# Statement of Objection

Application number 2025/60/93572/E

Outline application with all matters reserved, bar vehicle access into the site, for erection of up to 123 dwellings with associated works including open space, landscaping, drainage infrastructure.

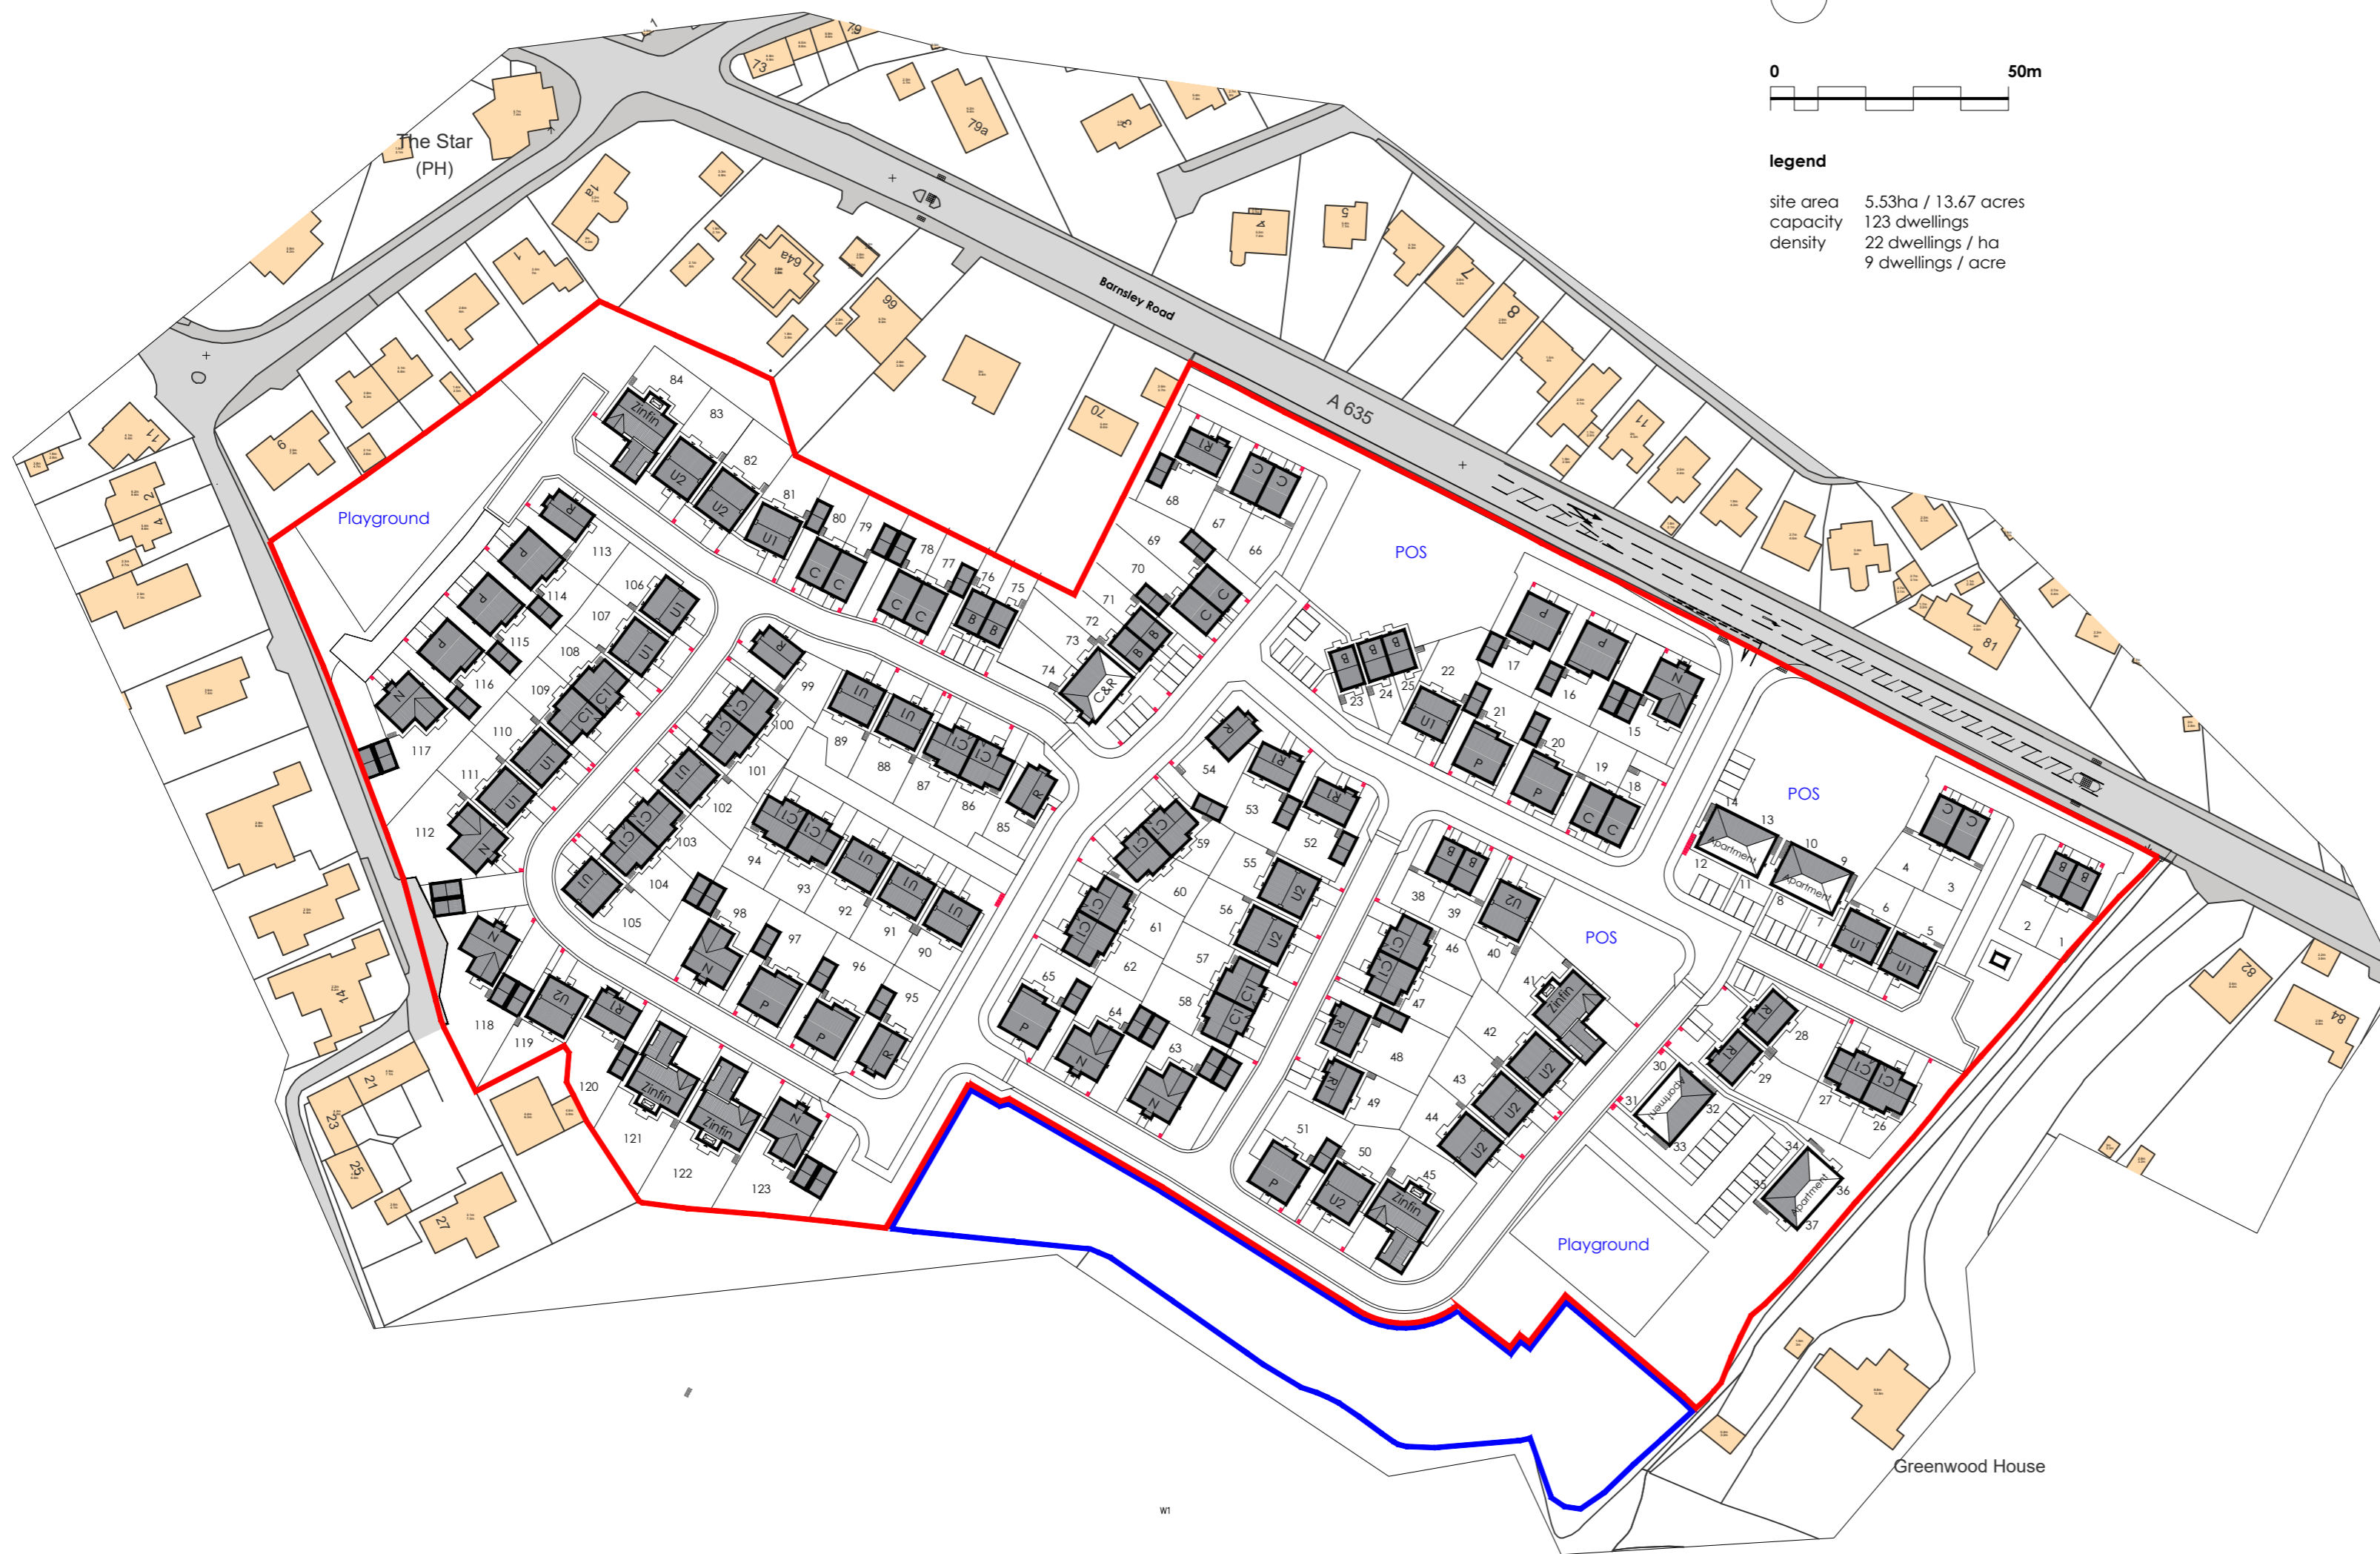
In terms of the proposed transition into green belt, there doesn't appear to be one. The plans indicate gardens to back straight on to agricultural land, this is not acceptable. It is of utmost importance to protect the green belt character if the surroundings, ensure the function of this land would not be impeded and to ensure the safety of the animals which graze.

A second access off Park Lane is indicated on some plans. This junction is dangerous and not suitable for additional vehicle movements.

The proposals would result in the loss of turning space for vehicles on Park Lane. Farm vehicles currently utilise the farmyard to turn so it is unclear as to how farm traffic will continue to access the landowner's other fields without having to reverse all the way up to Carr Hill Road which is of course a serious safety concern.

The proposal as shown with development occupying the farmyard would result in Lane Head Farm and the adjacent Weavers Cottage having no parking provision. Sufficient parking must be allowed for the farm and cottage within the site boundary.

It should also be noted that the line of combined sewer indicated on the plans submitted does not correlate with public records and plot 123 fouls with the easement.

Turning space on Park Lane for refuse vehicles and farm vehicles alike needs to be provided within the scheme.
